From: [REDACTED]
To: [A1 in Northumberland: Morpeth to Ellingham](#)
Subject: Comments on Progress on West View Design position
Date: 02 July 2021 13:07:41
Attachments: [TR010059-001465-Gareth Moor and Colin Moor - Other.pdf](#)

A1 in Northumberland

Summary of concerns regarding Proposed Road from Warners House / Northgate farm Through West View.

Figure 1 – DCO Application proposed PMA Route

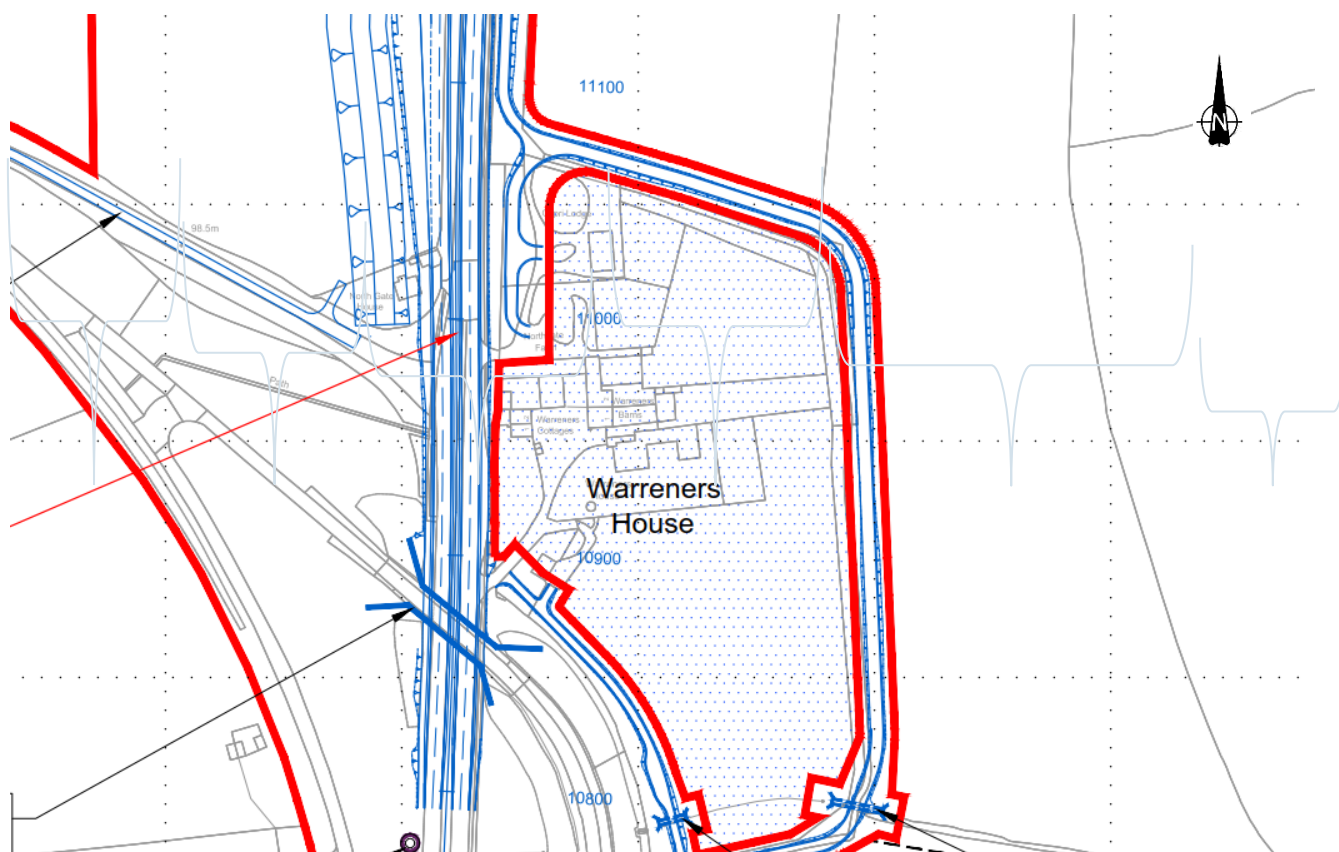
I have detailed previously that I do not consider this proposal to be the best option for this road the main reasons for this are on the grounds of safety, with particular concerns when the road is in use.

The designers under the Construction Design and Management Regulations have a duty to design out danger and whilst the applicant might argue that the regulations state where it is "reasonably practicable" I would state that it would have been much more reasonably practicable to go North with the access from Warreners and Northgate Farm. (These reasons are detailed in my reply to Deadline 4 copy attached)

Considering just the usage stage:- At present there is no agricultural traffic on West View. This design introduces such traffic which is contrary to the regulations, because danger is been designed in. In addition to this risk assessment requires the number of people who are affected by the risk to be taken into consideration. In the case of bringing the road South it affects close to 1000 people whilst the northern route affects only possibility 20 people therefore the likelihood of the risk been realised is 50 times greater going South.

The current proposals are not the safest options available the safest route and more practical route is to build is a northern route

4 This design would eliminate all agricultural traffic from a residential street and eliminate the risk to the residents of two new housing estates, hospital complex users, and West View occupants, visitors, and delivery personnel. In Short the risks are completely designed out, a fundamental requirement of the regulations that has not been adhered to in the proposed design.
